**Part Of OS Parcel 5720 East Of Kyleburn And  
West Of Manor Farm Main Street Wendlebury**

**23/03282/DISC**

**Proposal:** Discharge of Conditions 3 (means of access), 4 (field shelter details), 5 (waste bins and bin stores details) and 6 (Biodiversity Method Statement) of 23/02380/F

ACCESS DETAIL As Proposed
 1:500, 1:100 TPH October 2023
 Original at A1 Drwg no. 23 / 201.03 Rev A

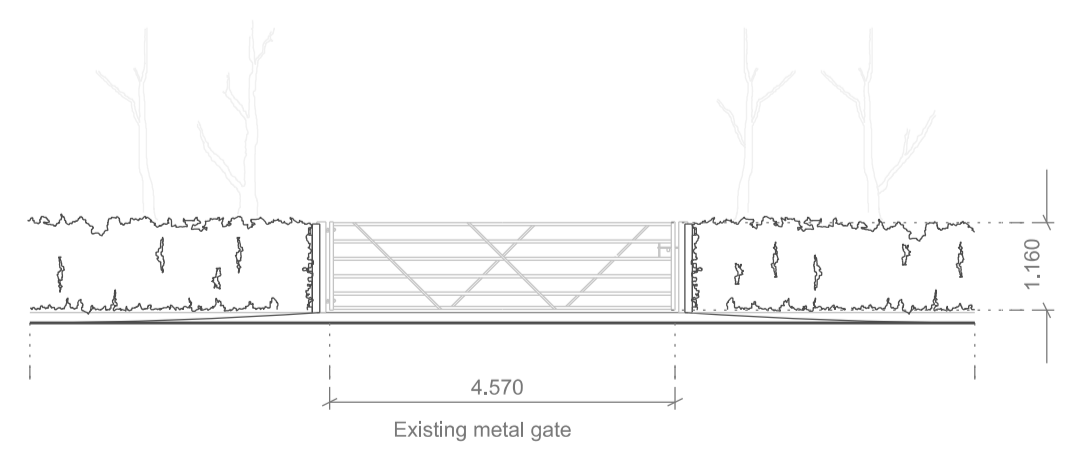
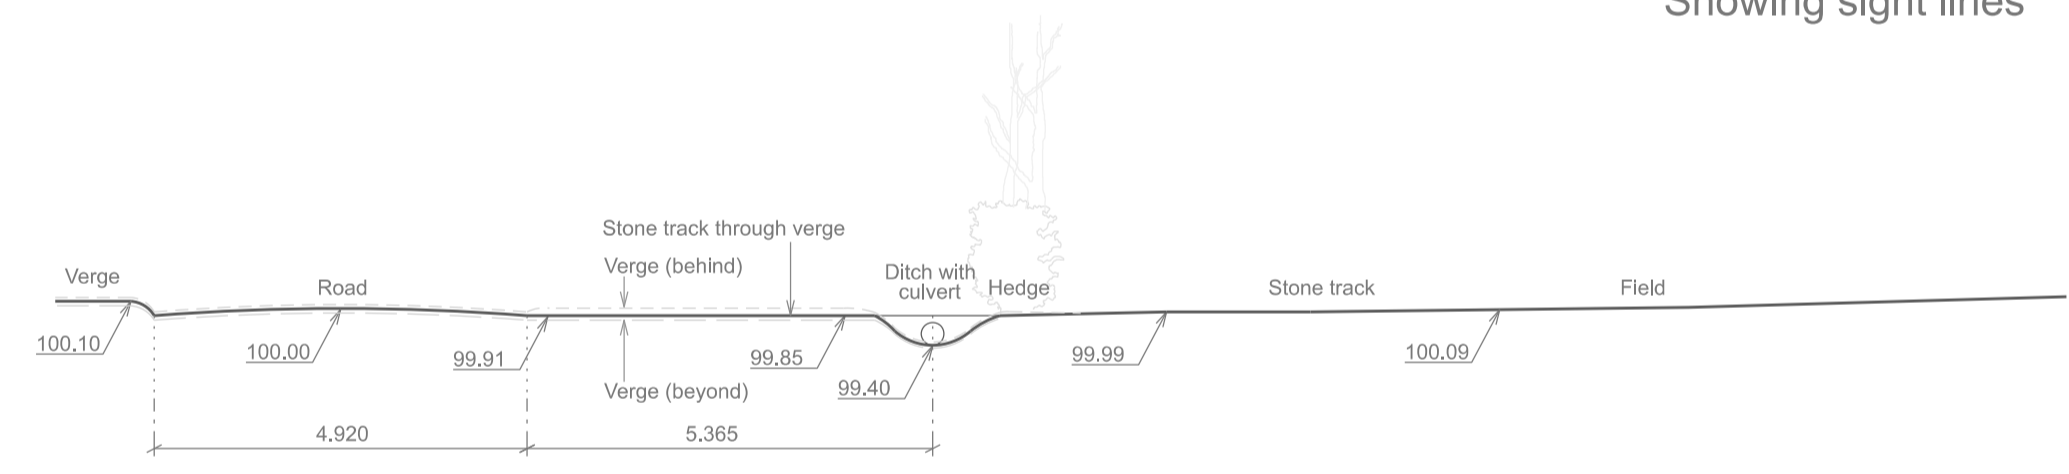
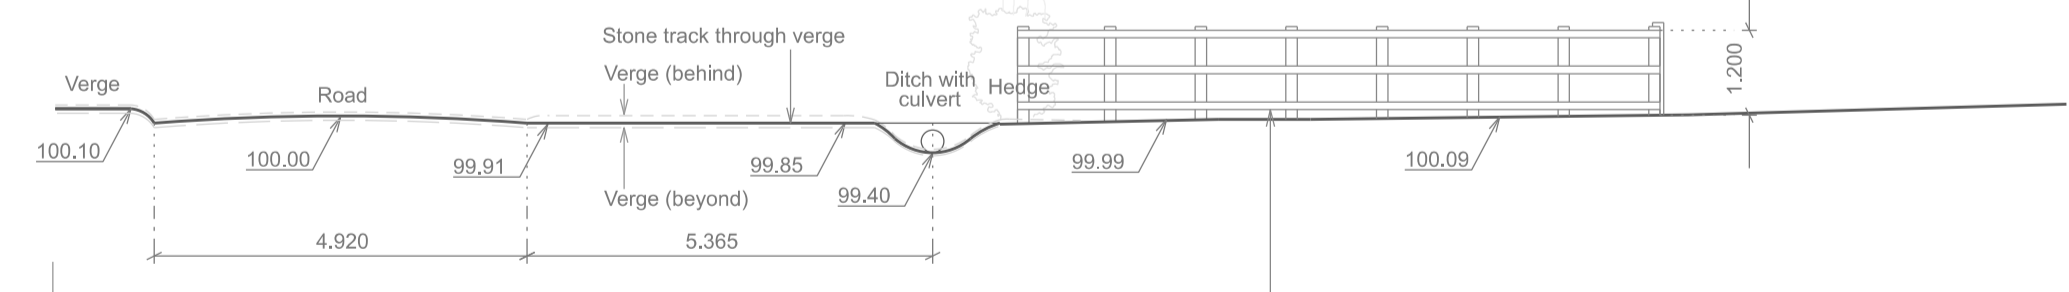
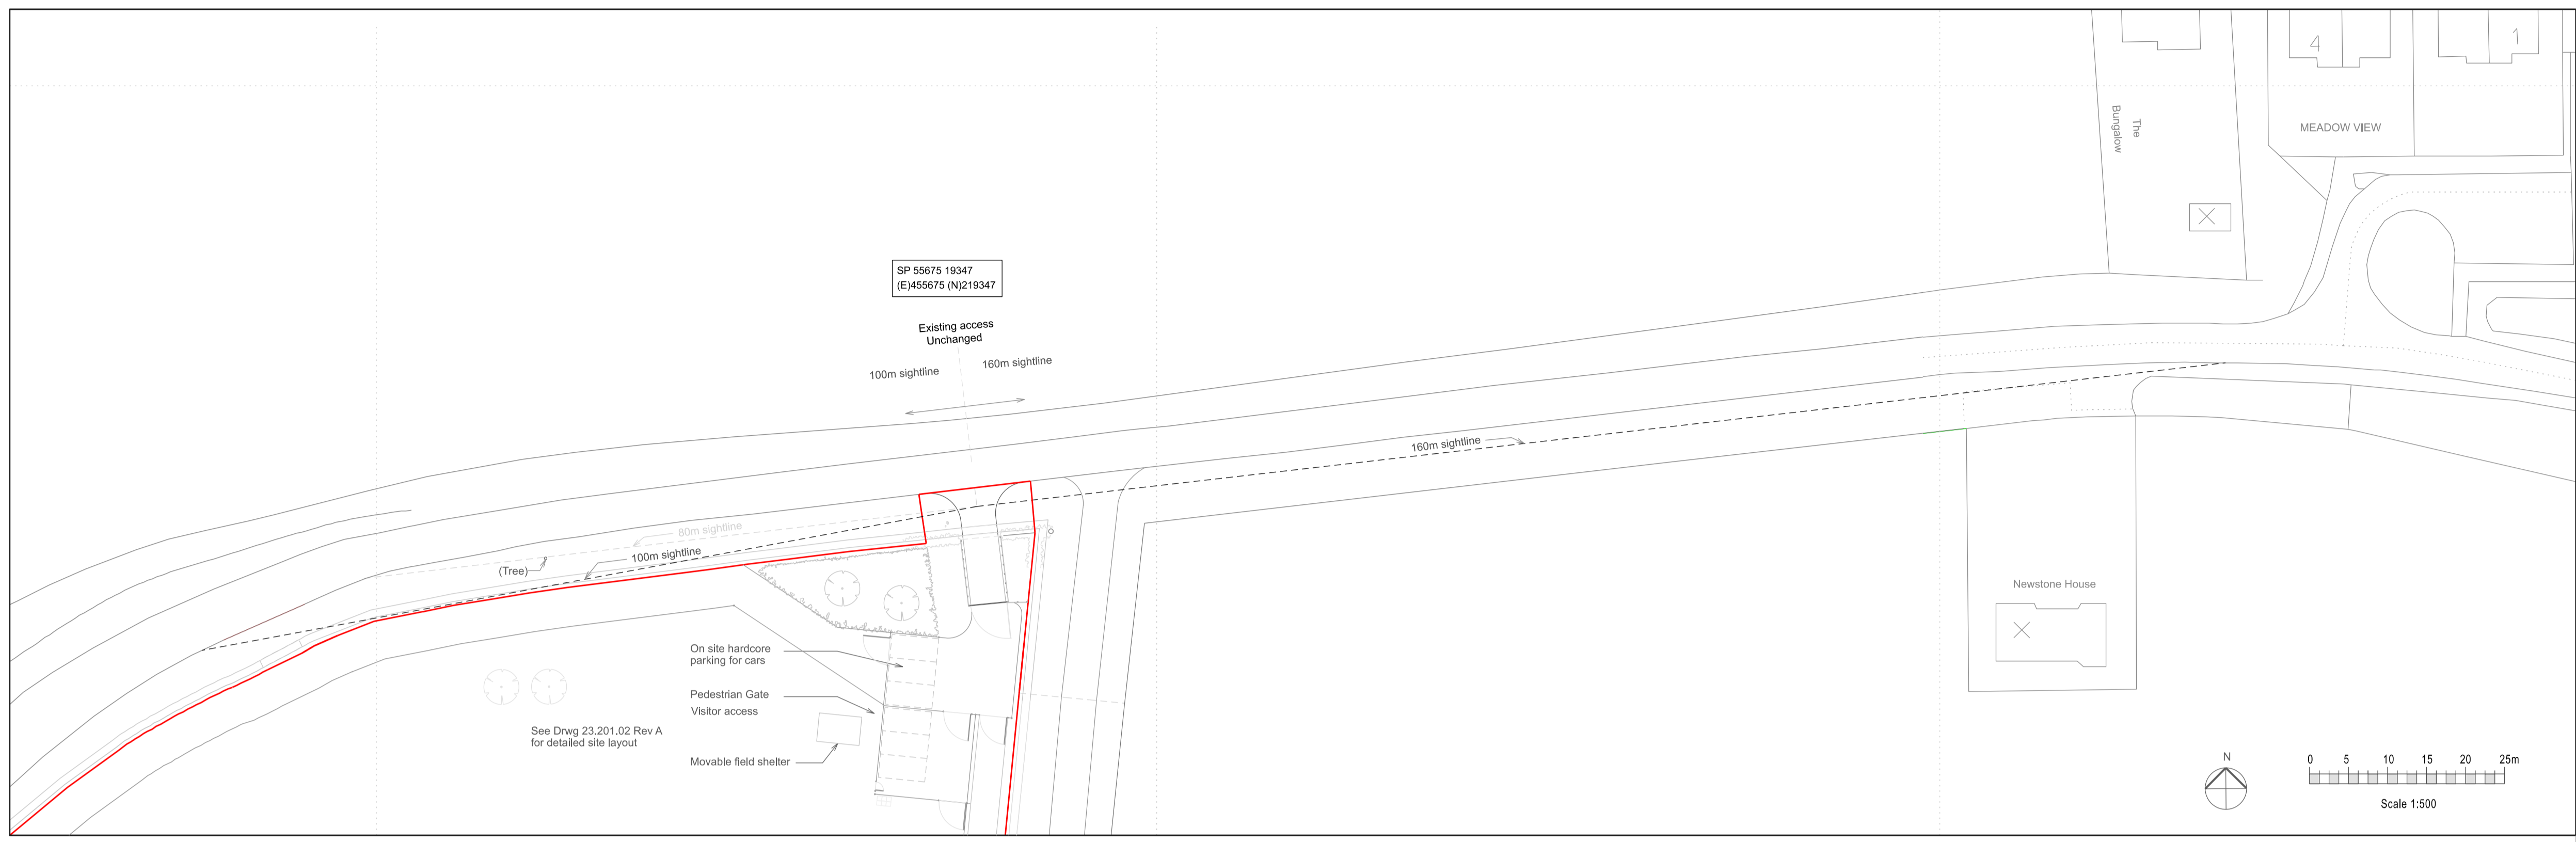
- 2.1. Condition 3 – sought details of the means of access between the land and highway. This was submitted in the form of an Addendum to the Design and Access Statement dated 23 November 2023 and Drawing No. 23.201.03 Rev. A indicating that the existing access would not alter.

6.1. Condition 3 – The Highway Authority has agreed that the existing access can remain, and I have no reason to disagree with this assessment.

Condition 3 – Means of access between the land and the highway in accordance with Addendum to the Design and Access Statement dated 23 November 2023 and Drawing No. 23.201.03 Rev. A.

FIELD SHELTER DETAIL As Proposed
 1:50 TPH November 2023
 Original at A1 Drwg no. 23 / 201.04

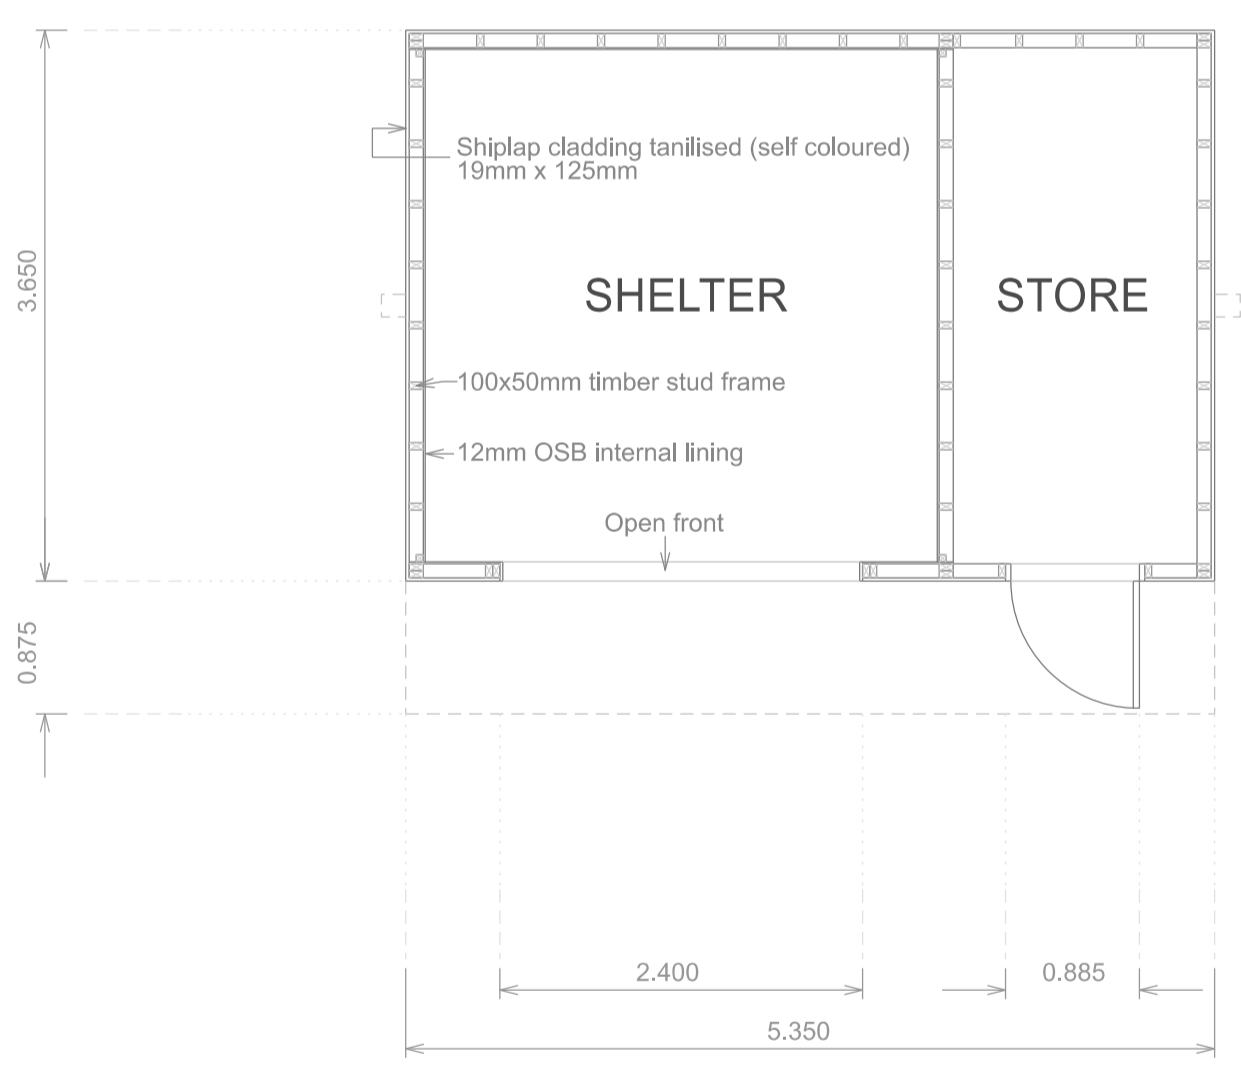
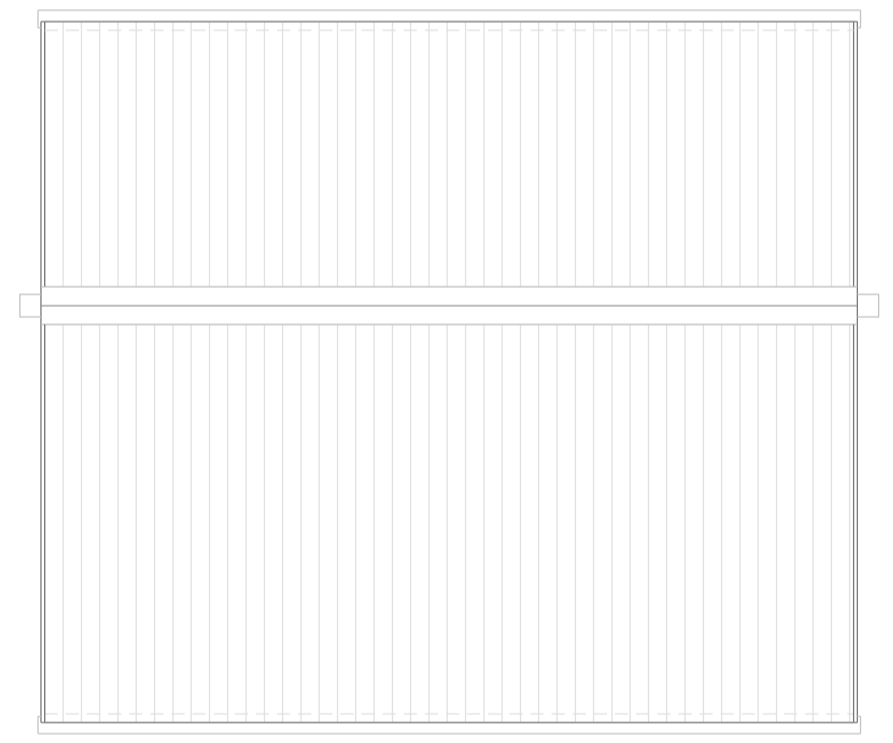
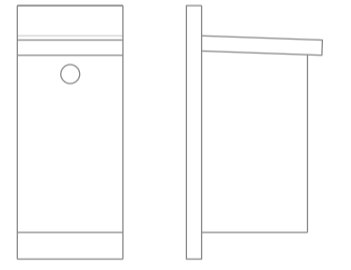
- 2.2. Condition 4 – sought design details of the field shelter. This was submitted in the form of an Addendum to the Design and Access Statement dated 23 November 2023 and Drawing No's. 23.201.02 Rev. A and 23.201.04 indicating the position and appearance of the field shelter. Note the field shelter would be 55cm taller than that referred to in the original application.

6.2. Condition 4 – This condition was attached due to the lack of information supplied with the application with regard to the position and appearance of the field shelter. Whilst the field shelter now proposed is 55cm taller than the figure provided in the original application, the condition was applied “notwithstanding” the approved details, and given the isolated nature of the site, I do not consider this increase to represent a significant deviation from the approved scheme.

6.4. Conditions 6 – Whilst the Ecology Officer has not provided any comments on the scheme, 2 bird nest boxes would be installed and 18 new trees would be planted, which would, in my opinion, constitute an enhancement for biodiversity within the site. I therefore consider the details to be acceptable.

Statement dated 23 November 2023 and Drawing No's. 23.201.02 Rev. A and 23.201.04.

Condition 6 – Method statement for enhancing biodiversity in accordance with Addendum to the Design and Access Statement dated 23 November 2023 and Drawing No's. 23.201.02 Rev. A and 23.201.04.
